Subject	2-32 SMITH STREET, SUMMER HILL, PROJECT APPLICATION
File Ref	FM APRIL 2013
Prepared by	Con Colot - Senior Strategic Planner & Projects
Reasons	Provide the Department of Planning & Infrastructure with comments on the Project Application for Stage 1 at the Flour Mills site, 2-32 Smith Street Summer Hill.
Objective	For Council to determine its response to the project plan application.

1.0 Purpose of Report

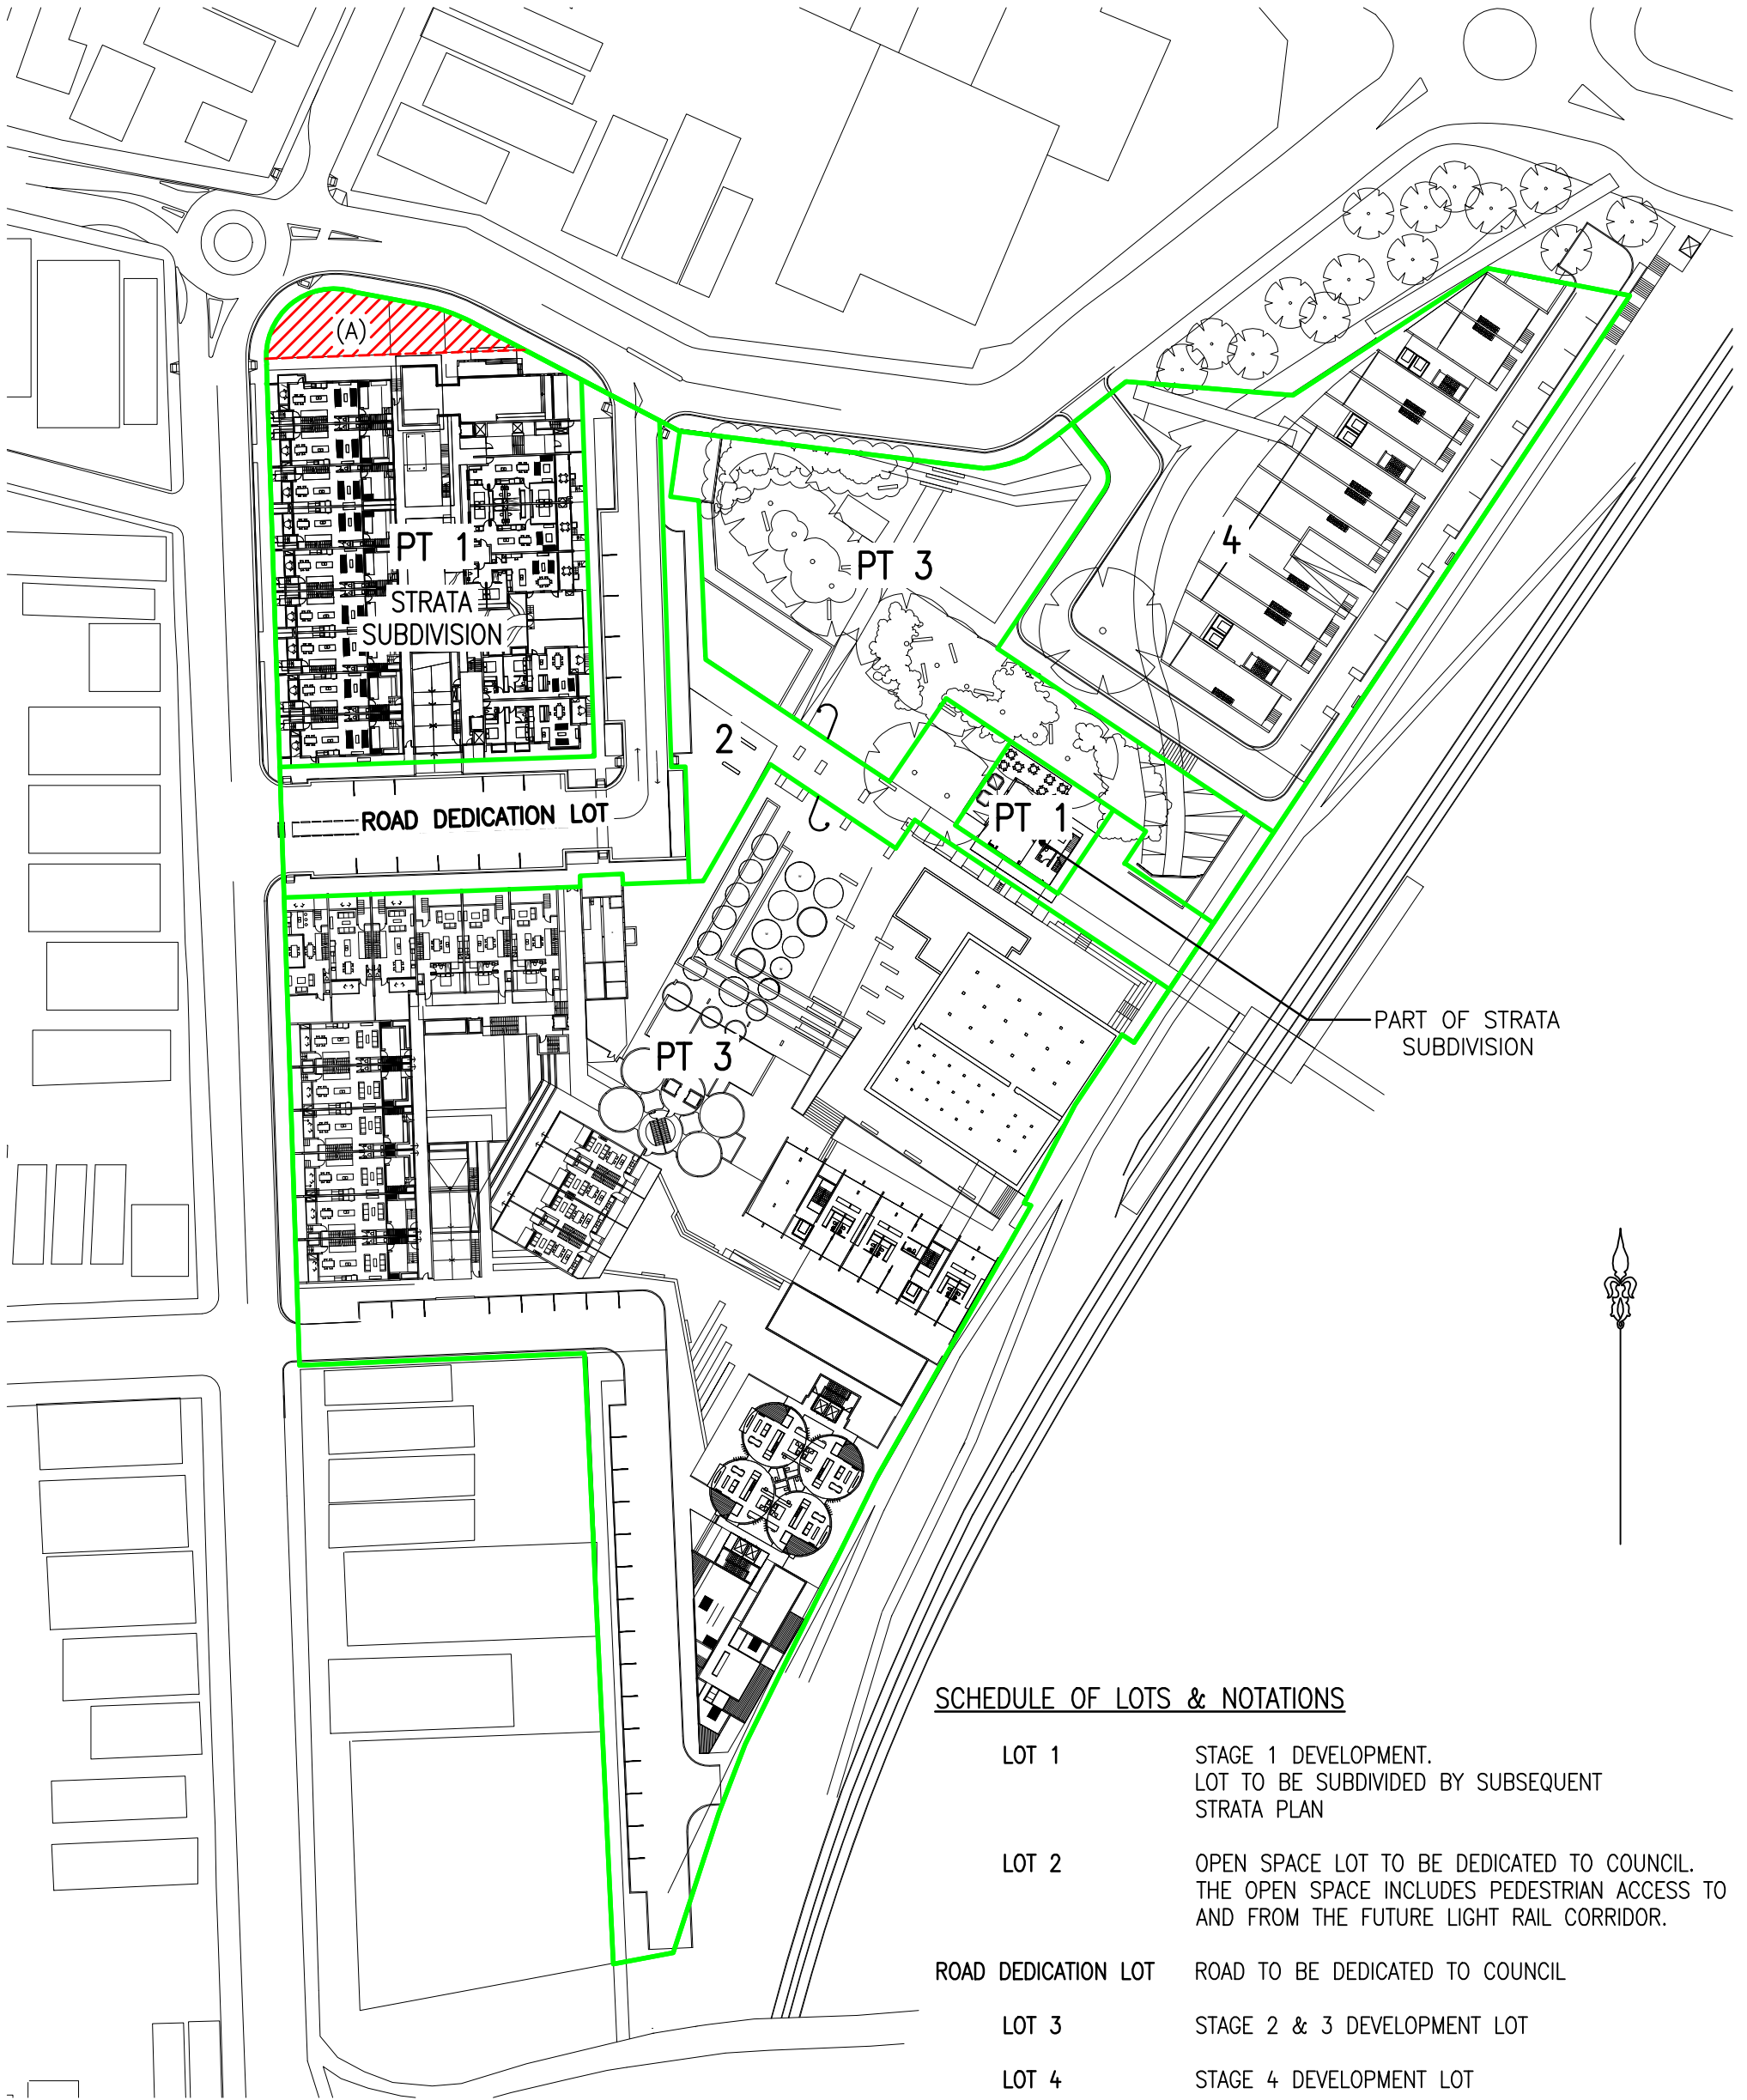
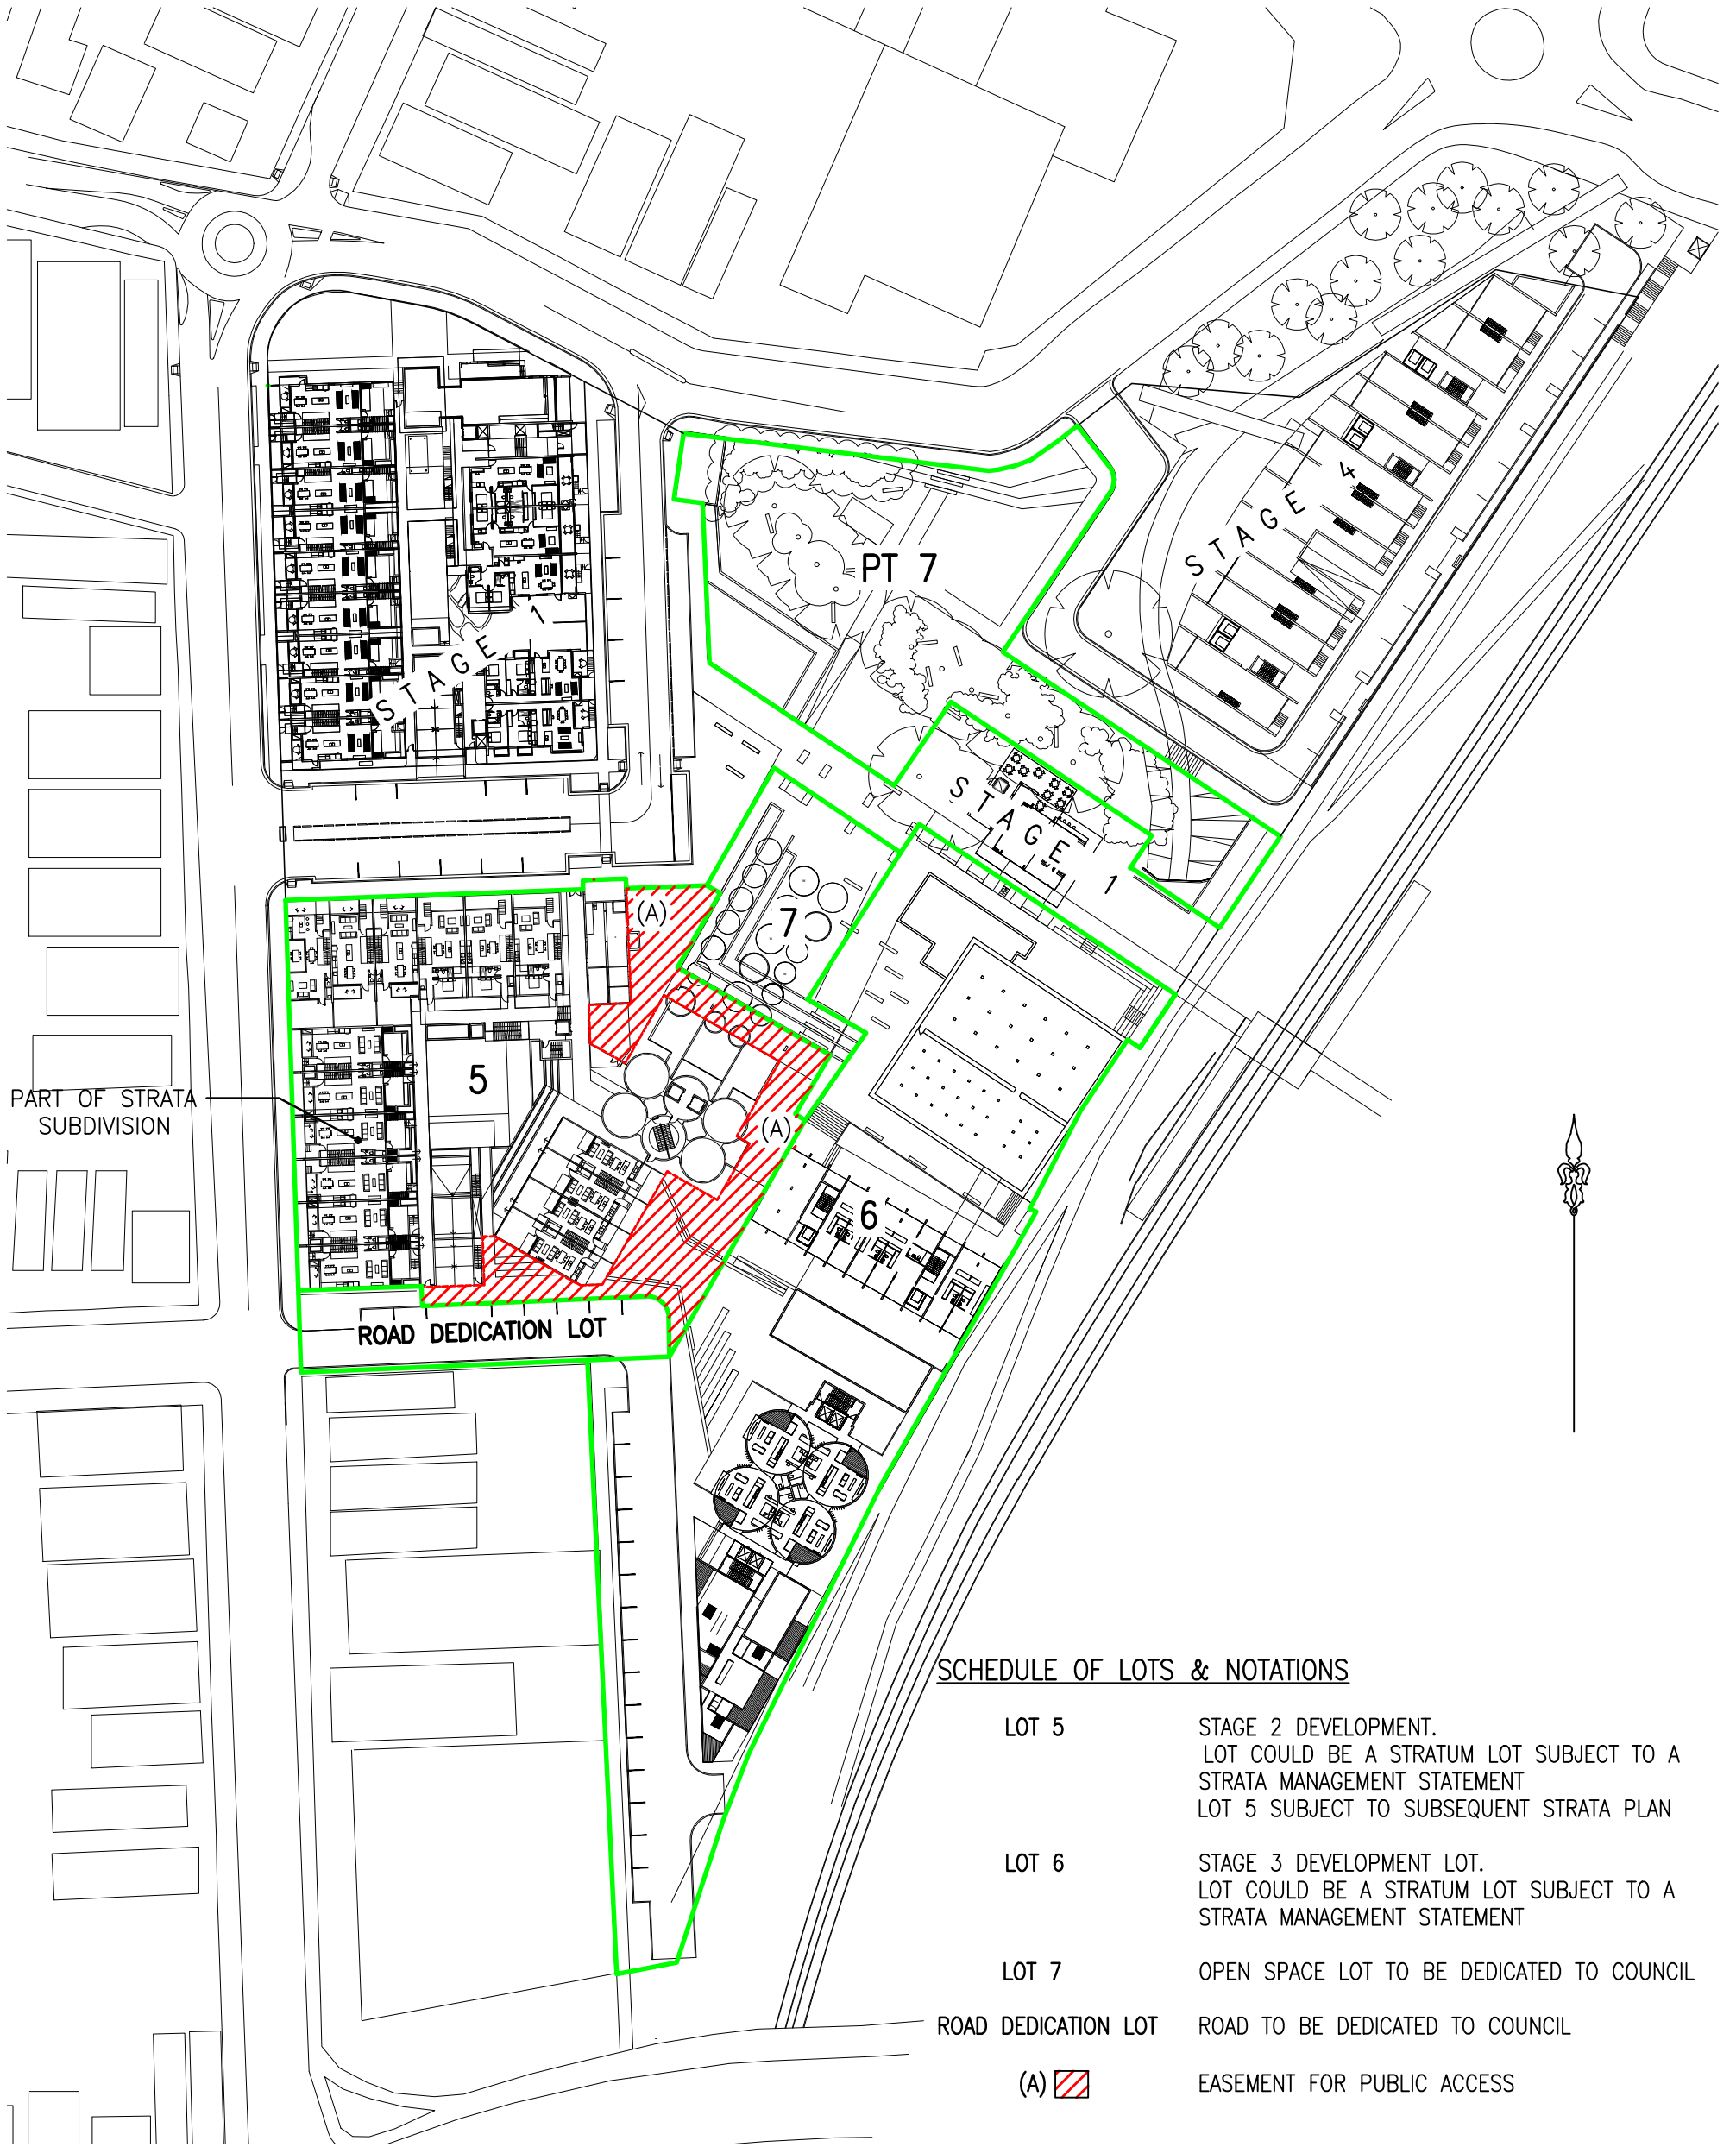
The development is proposed to be staged in 6 parts, as shown on the 'Indicative Subdivision Plan' (DA -012), and as shown in **Diagram 2** of this report.

As previously brought to the attention of the Department, once land subdivision occurs, each allotment will potentially be able to be sold to individual owners and separately developed. This creates uncertainty about how each development stage will address the complexities and share the burden of complying with the numerous Concept Plan conditions, and for example provide the various infrastructure works located on other parts of the site or external to the site. Another issue is whether different land owners will be willing to comply with the Concept Plan approval conditions, or instead seek amendment of the conditions.

In order to provide certainty to the Concept Plan approval conditions 23, 24, 25 and 26 (see extract under **Diagram 2**) which require publicly accessible open space and a public access way to the Light Rail station, a condition should be placed on any Project Application approval reflecting the Concept Plan conditions 23, 24, 25 and 26 and requiring that the relevant 'restriction as to user' be placed on all the relevant land titles.
